1 April 2014

Our Ref: P3A-2012/1
Contact: Marta M Gonzalez-Valdes - 9562 1743

Re: Stage 1 Discovery Point (MP 10_0030 MOD 3) 1 Princes Highway, Wolli Creek

Streetlights - Proposed Bega outrigger luminaire and Street Banner Pole

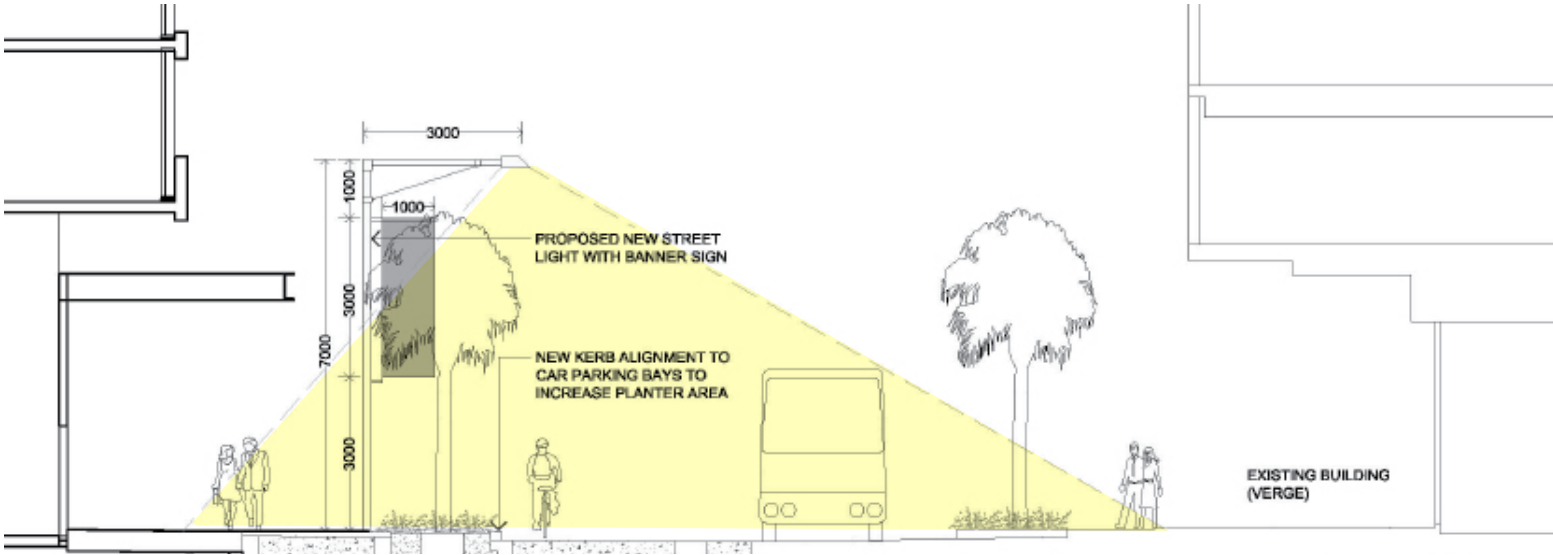
1. An easement is to be registered prior to the issue of the Occupation Certificate to ensure that Discovery Point residents have access to all facilities within Stage 1.
2. The nominated street lights as referenced in the Wolli Creek and Bonar St Public Domain Plan are no longer acceptable to Council or Ausgrid. The proponent is to liaise with Council's Tech Services for an alternative light fitting that meets with the approval of Ausgrid and Council.
3. Final planting plans showing location and arrangement of species will need to be issued at future detailed design stages.

It is noted that the proposal is subject to conditions of the consent B2 and B3. Therefore the issues raised in items 2 and 3 above are to be considered as part of achieving compliance with these conditions.
